Address: 3 Vernon Close Huddersfield HD15QE

Application number: 2025/90829	
What is the application for?:	Erection of detached dwelling with detached garage
Address of the site or building:	Land adj, 3, Vernon Close, Edgerton, Huddersfield, HD15QE
Postcode:	HD2 1DD

1 Site Plan
1 : 250

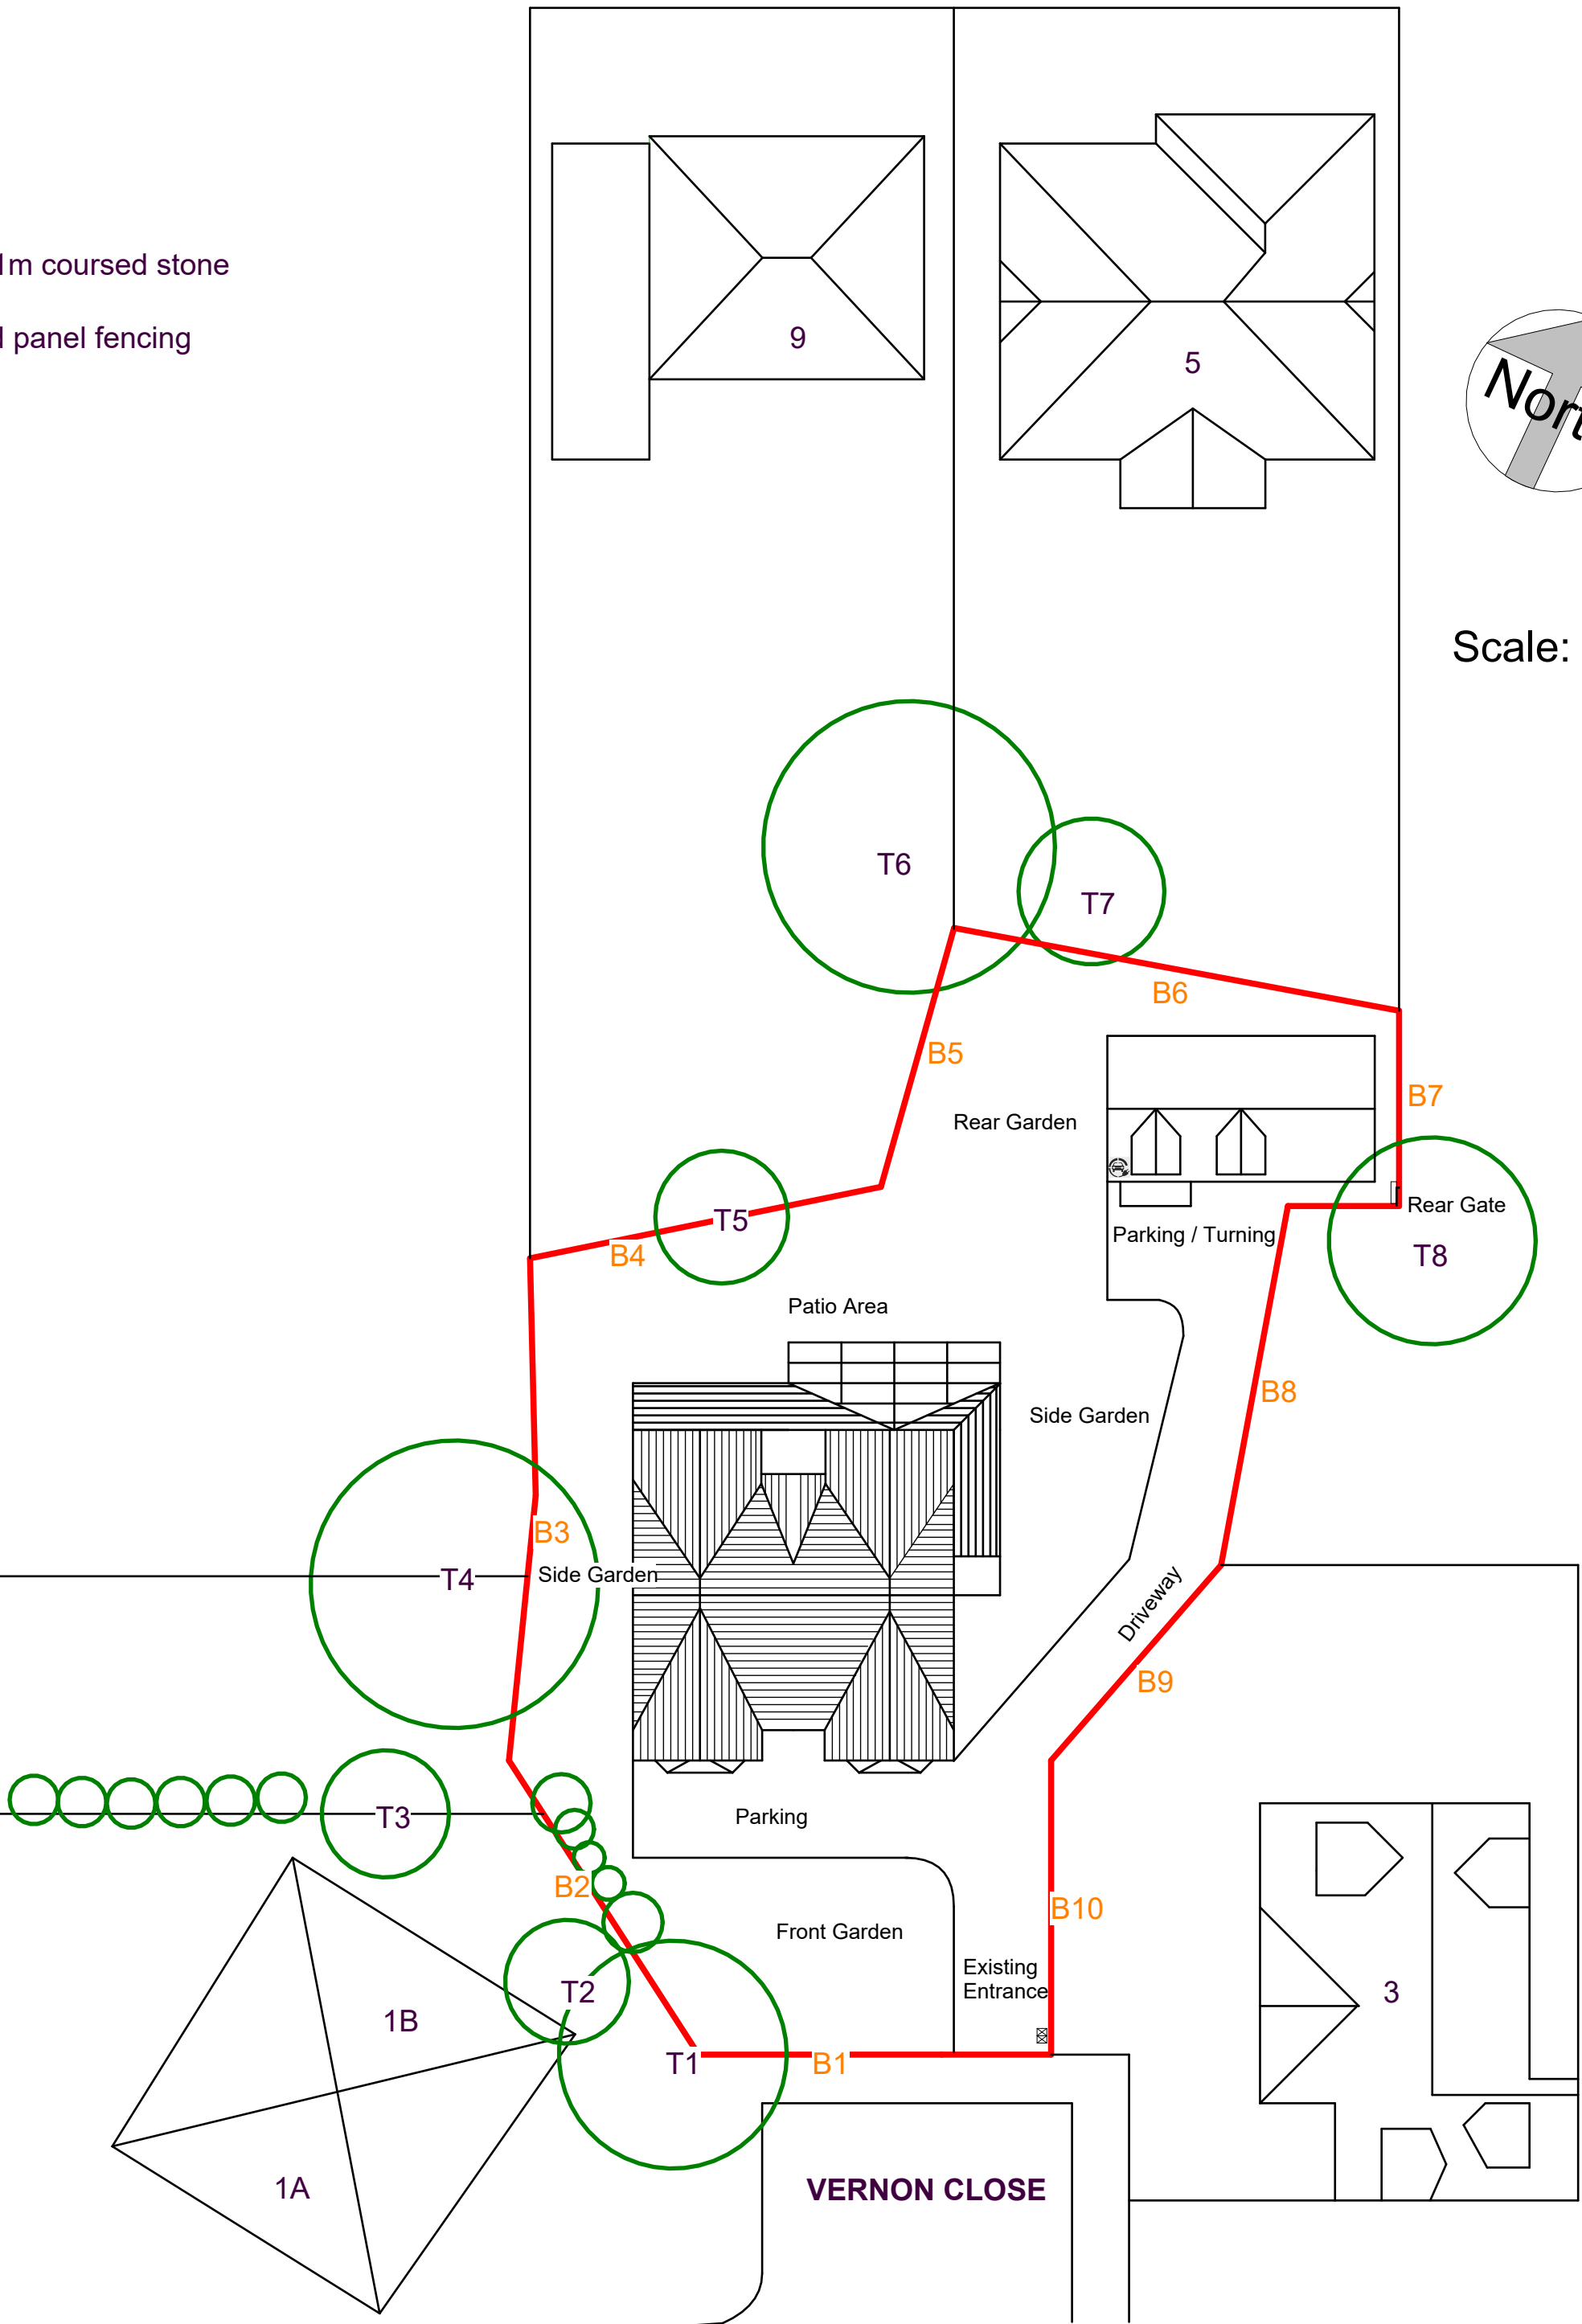
Type of comment: An objection	
Do you wish your comments to be published on the website anonymously?	No
<p>Hi,</p> <p>I am concerned about light issues. Based on the plan it looks as though the neighbours will lose sunlight. Can it please be checked that this is in line with current rules?</p> <p>On a similar vein these plans look like they will overlook various neighbours houses. Please can this also be reviewed</p>
